CITY OF ALBUQUERQUE

November 19, 2014

**Re: Coronado Villa Retirement Community, Tract 4B
Grading and Drainage Plan
Engineer's Date 11-11-14 (D18D054C)**

Date:	No.:	Revision:	Date:	Job No.:
9/10/14				2051
Drawn By:				CG-101
Chk By:				SH OF

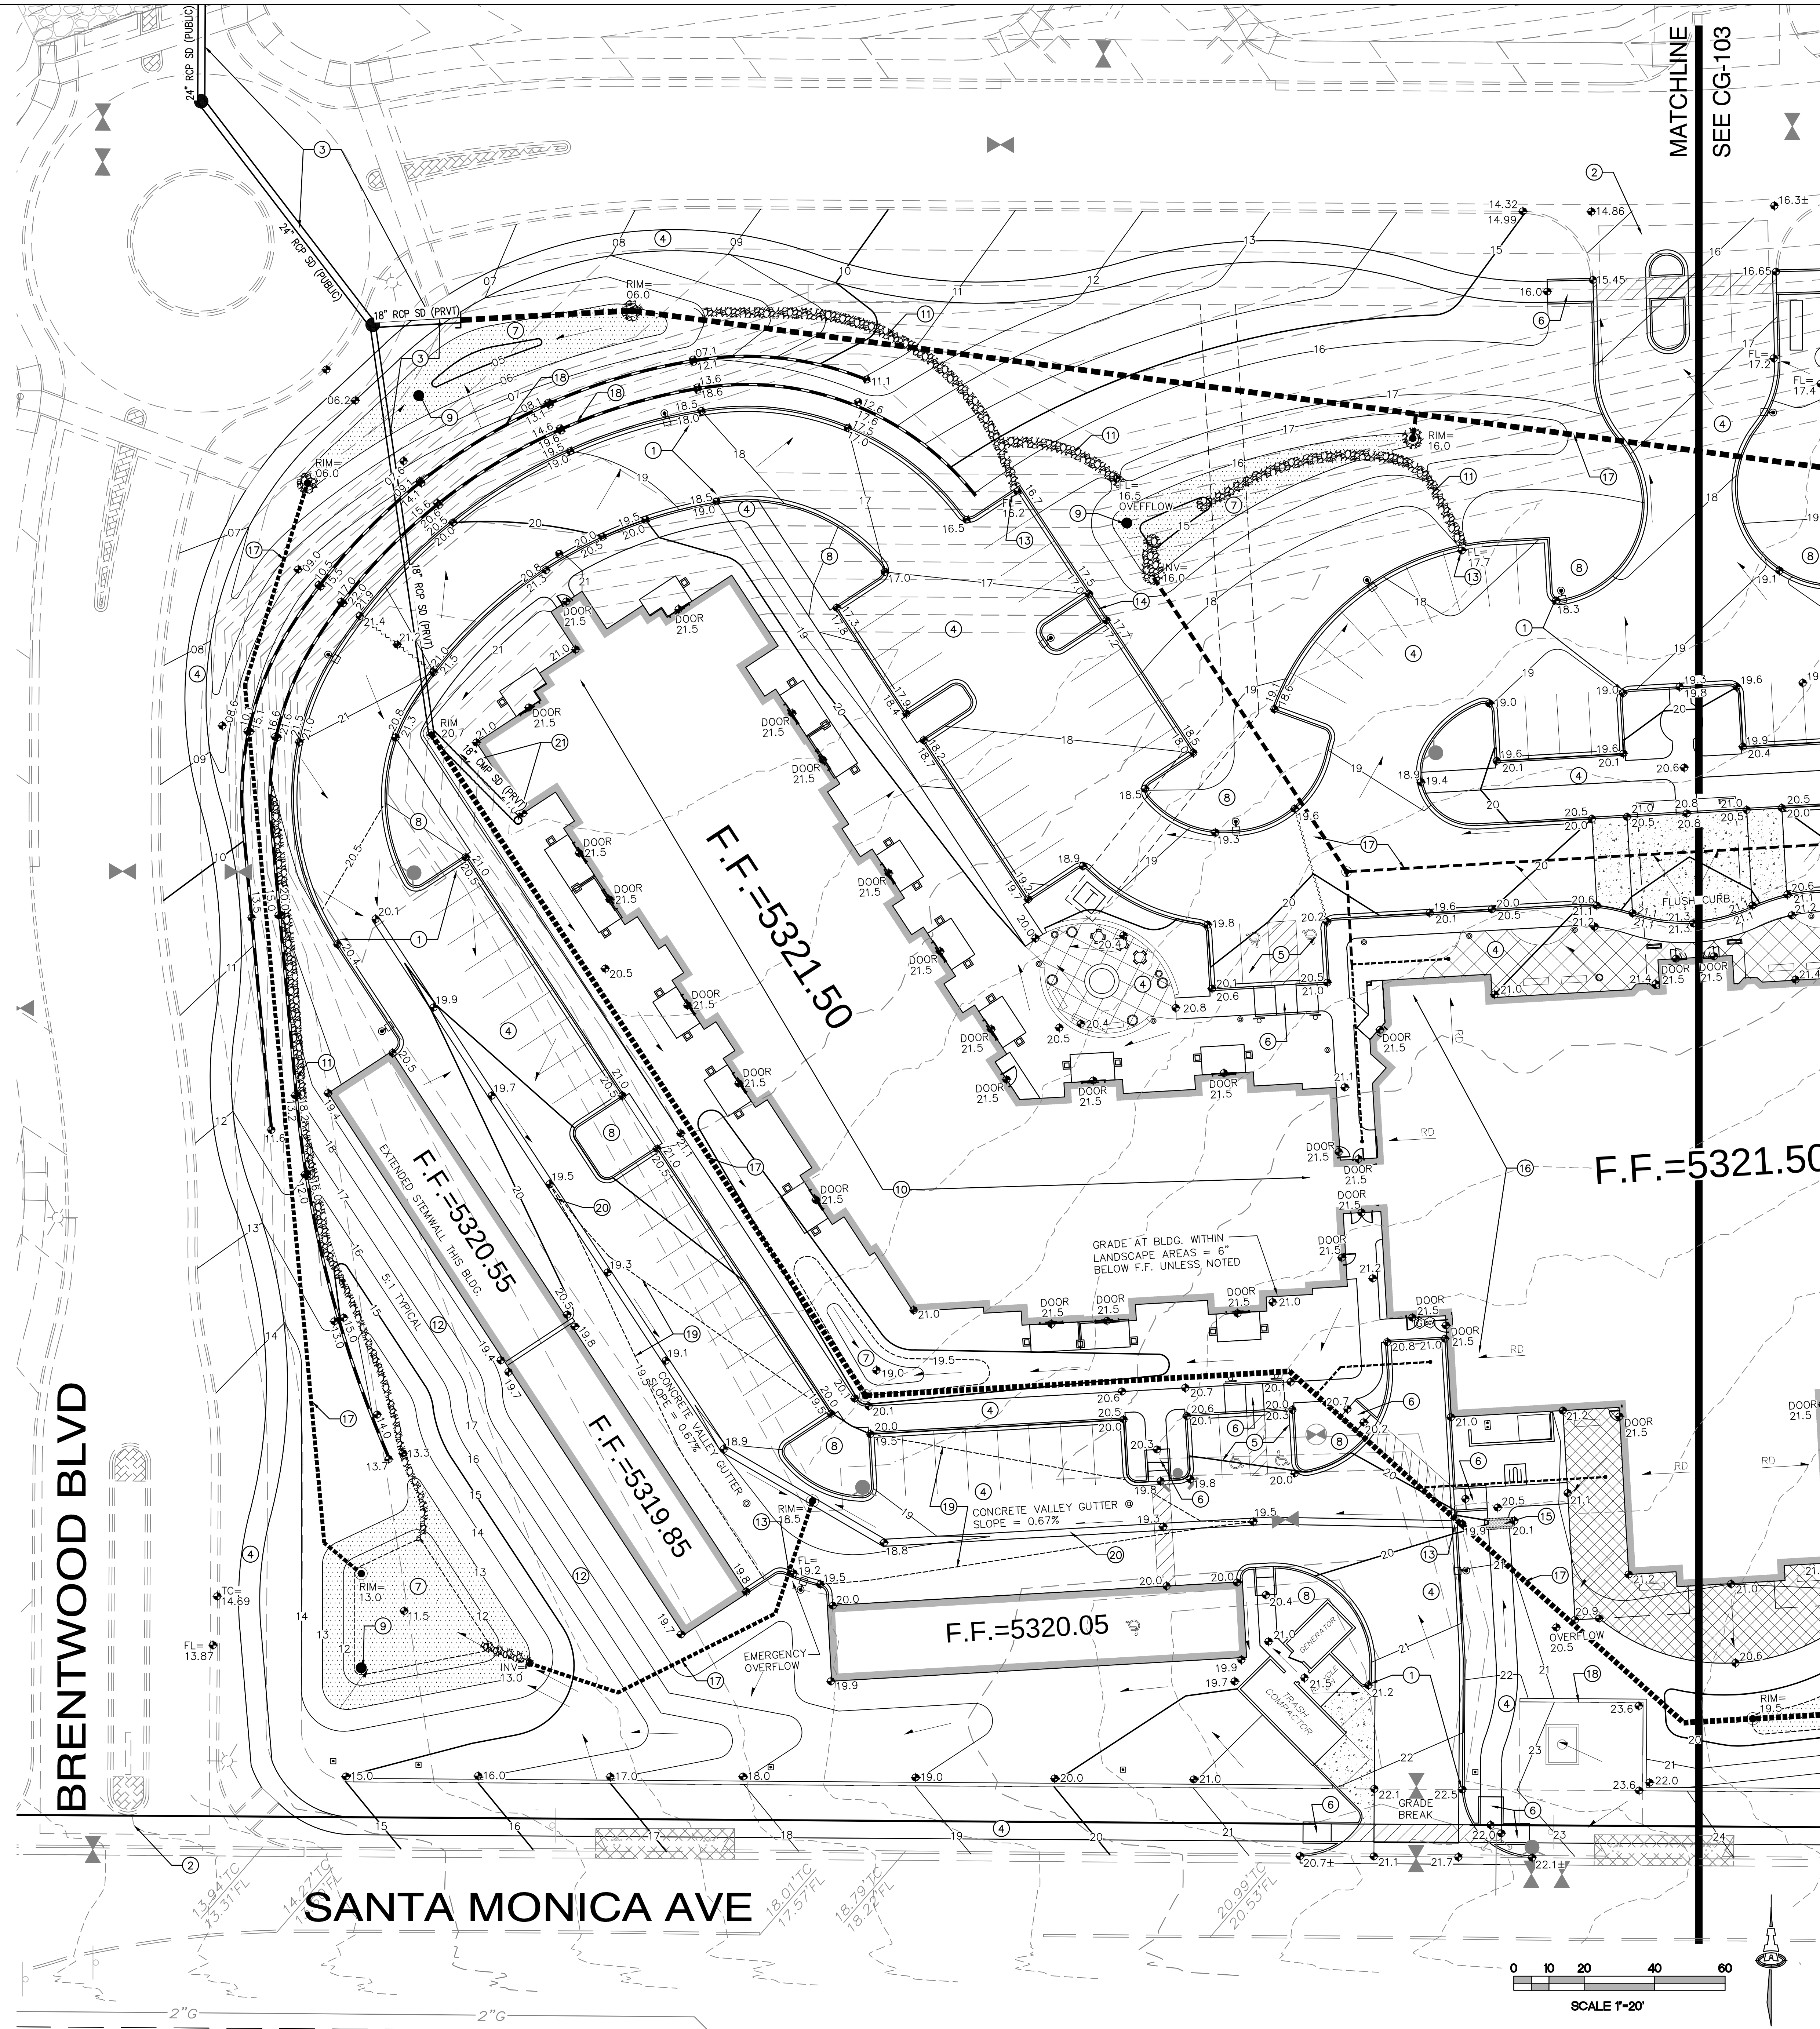
1. Provide a detail for the swales. Include the width also.
2. Keyed Note #15 on Sheets on CG-102 and CG-103 call out a sidewalk detail on CP-501 (not CG). Provide the detail on CG-501.
3. Provide legends on the sheets.
